<b>Project:</b>	Park Danforth
<b>Location:</b>	Portland, ME
<b>Becker Job No:</b>	3422

**OBSERVATION REPORT**

Cast in Place Concrete

**AUDITORIUM & CONNECTOR FOUNDATION PLAN**

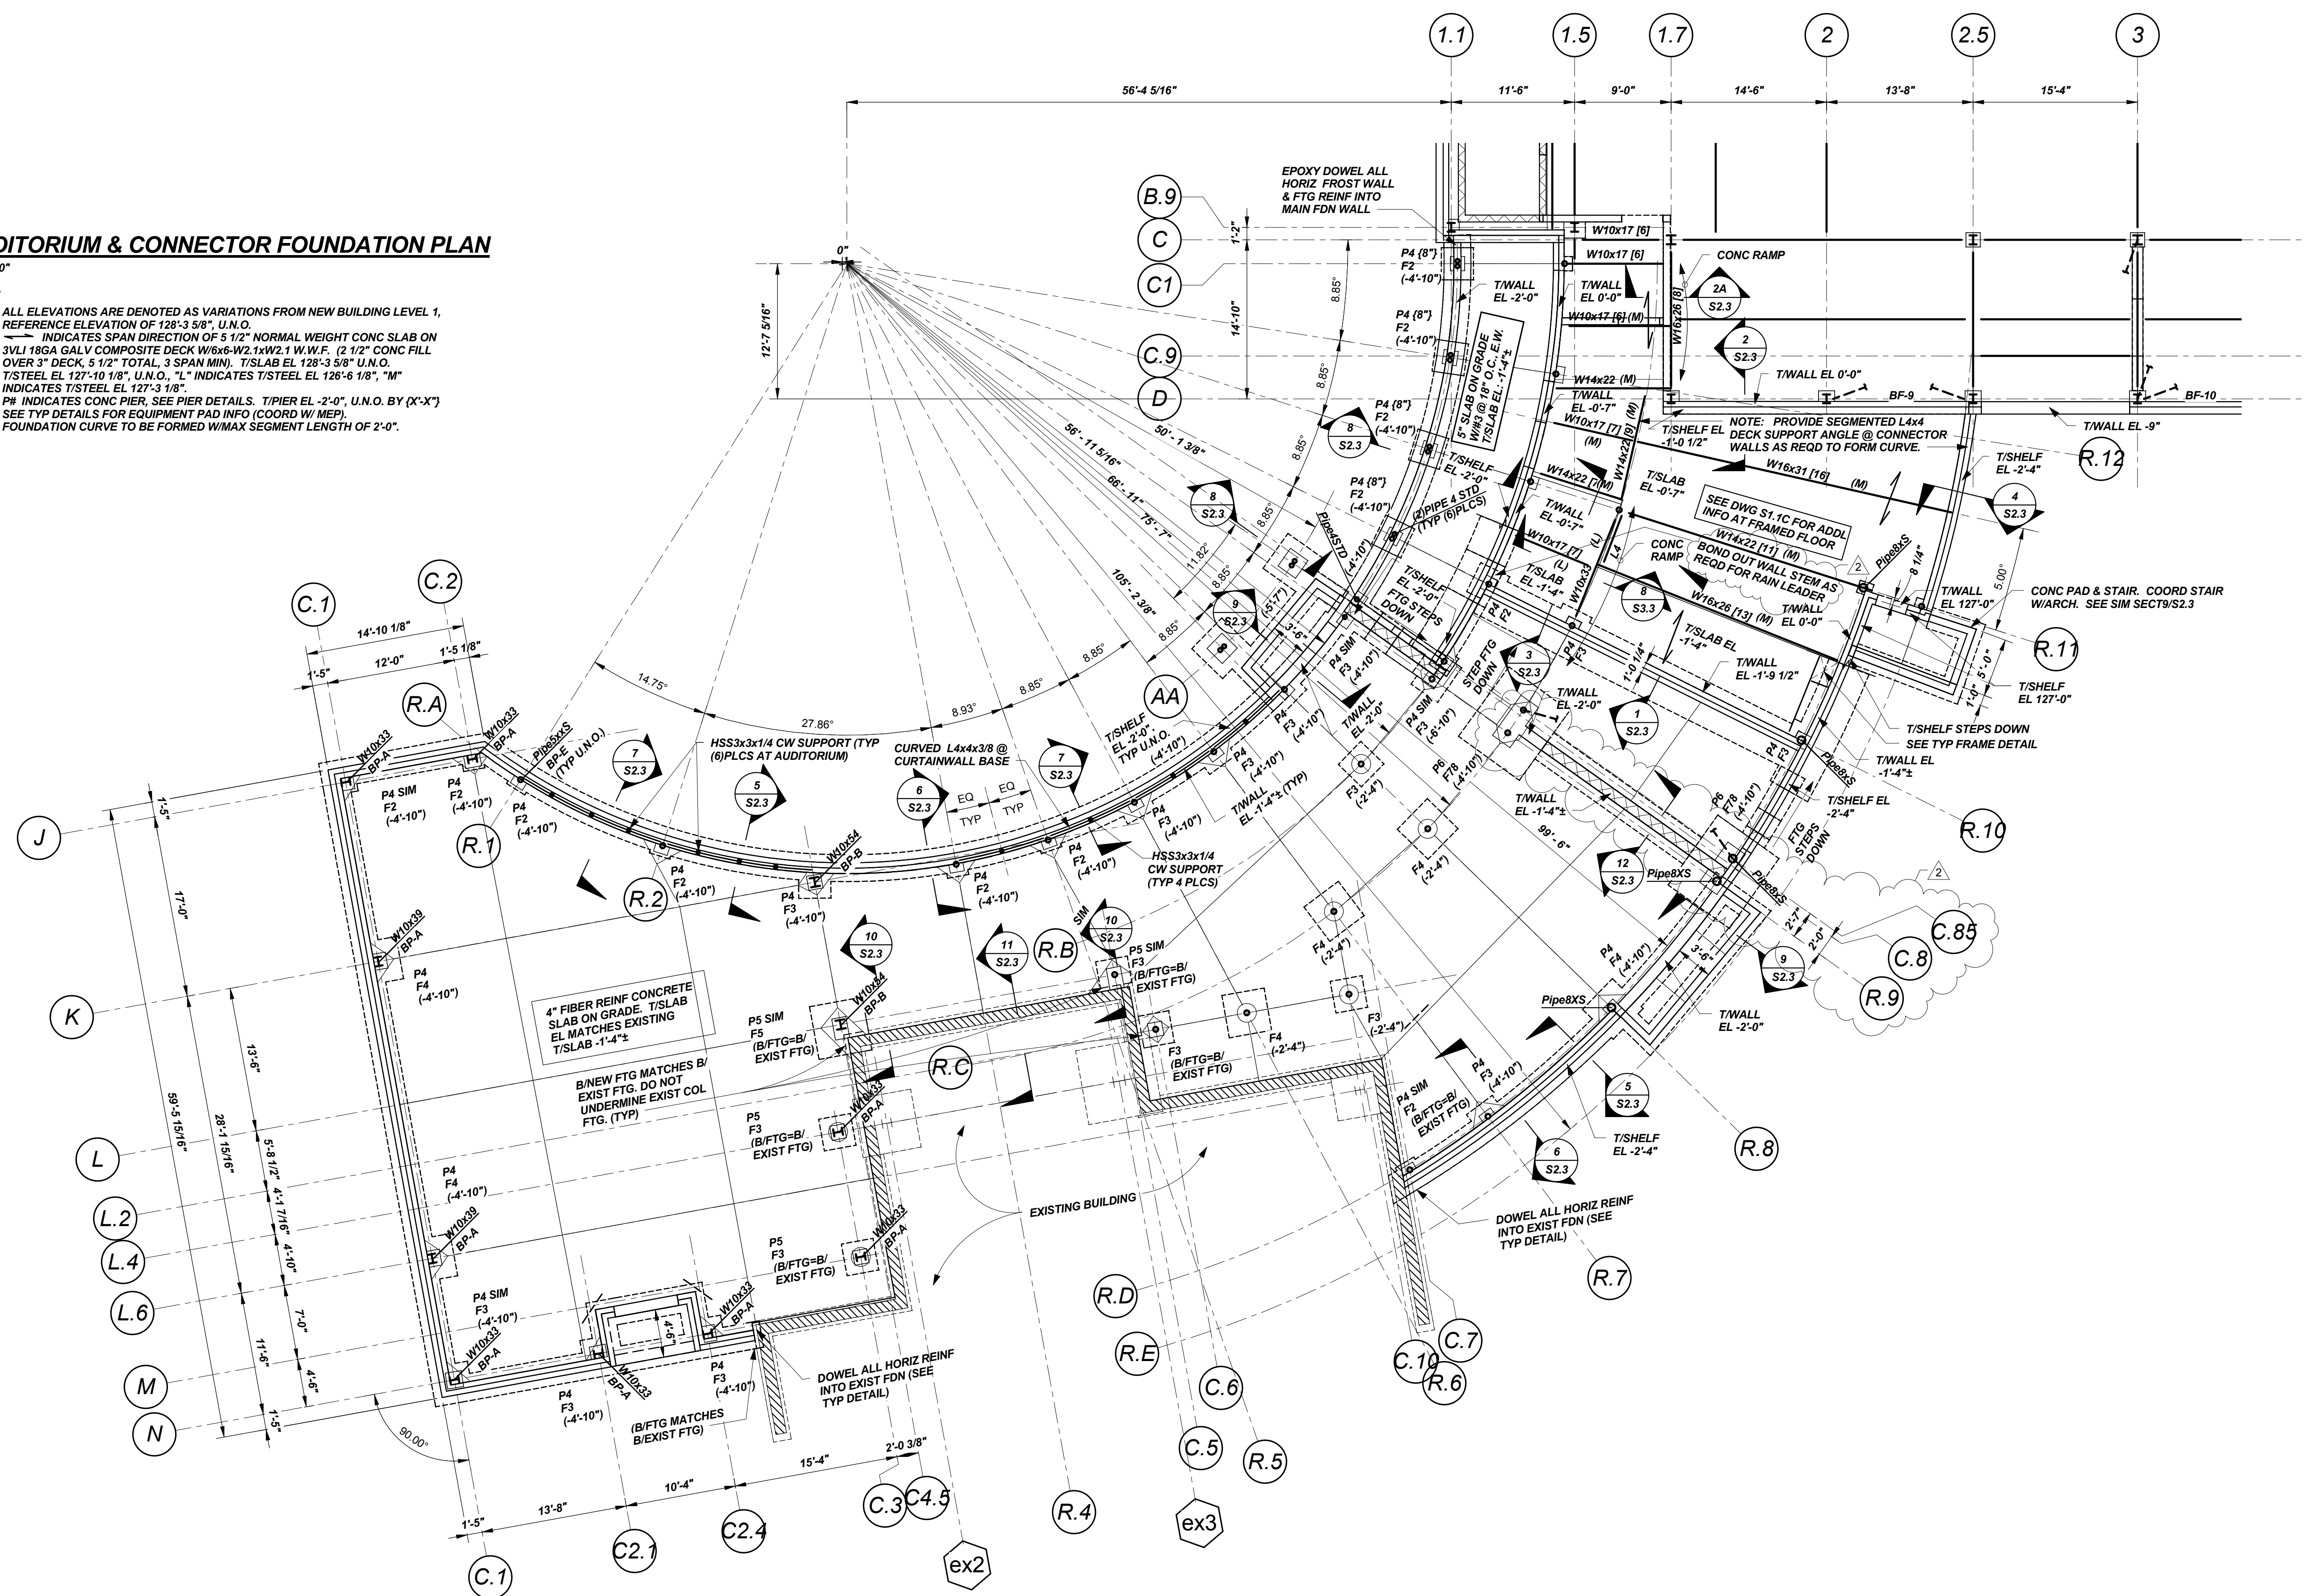
Connector:  
 Foundation walls around the auditorium, on R.A line from R.1-R.4, on R.D line from C.7-R.10, on R.9/C.85 line from R.C-R.D.  
 Isolated piers C.3/L.4, C4.5/L, C.5/L, and C.6/L.2.  
 Isolated footings R.6/R.C, C.10/R.C, R.7/R.C, R.8/R.B, and R.8/R.C.  
 Continuous wall footings on R.A from R.5-C, entry frost wall, and R.9/C.85 line from R.A-R.B were being constructed at the time of the visit.

From report 06-30-16 at C.1 line between K and L there was a pipe passing through the new footing. Giles stepped the footing down in order to pass the pipe through the wall as was previously discussed in report 06-30-16.

I provided a hand sketch detail to Giles and PC the morning of 7/13/16 on how to tie pier C4.5/L to the existing foundation wall.
